P/13/13/

From: Geoff Barter [REDACTED]
Sent: 12 March 2013 10:43
To: Julie Grievess
Subject: RE: Further Information required to validate application P/13/13/ - [Your ref: [application/reference/agent_ref]]
Attachments: KingsDrive045B.pdf

Thank you for your email concerning the application for 45 Kings Drive, Pagham.

PROPOSED SITE PLAN 1:200

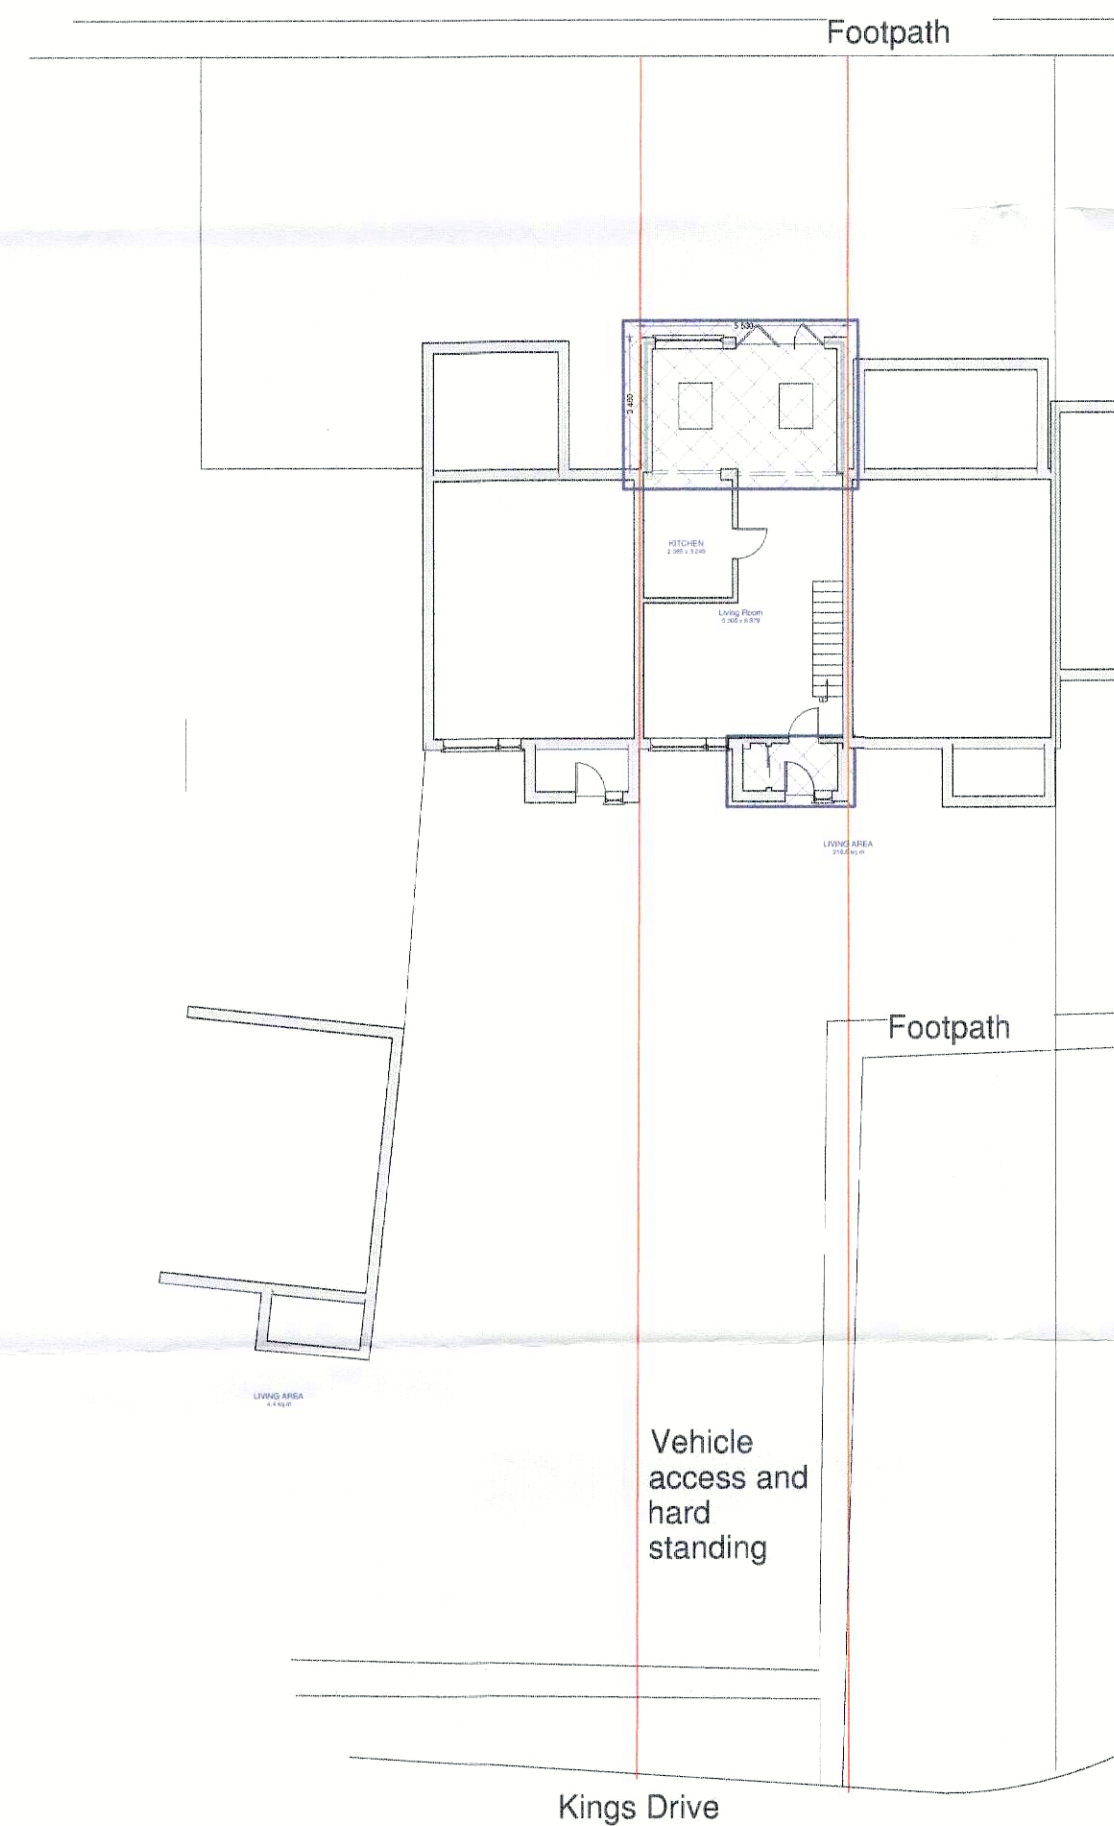
The proposed works have to be clear on the block plan. I appreciate its at first floor level but you can shade the porch area.

Thank you for the email. Could you highlight the porch area as another extension will be constructed there aswell

The block plan now has both extensions edged and hatched in blue as requested.
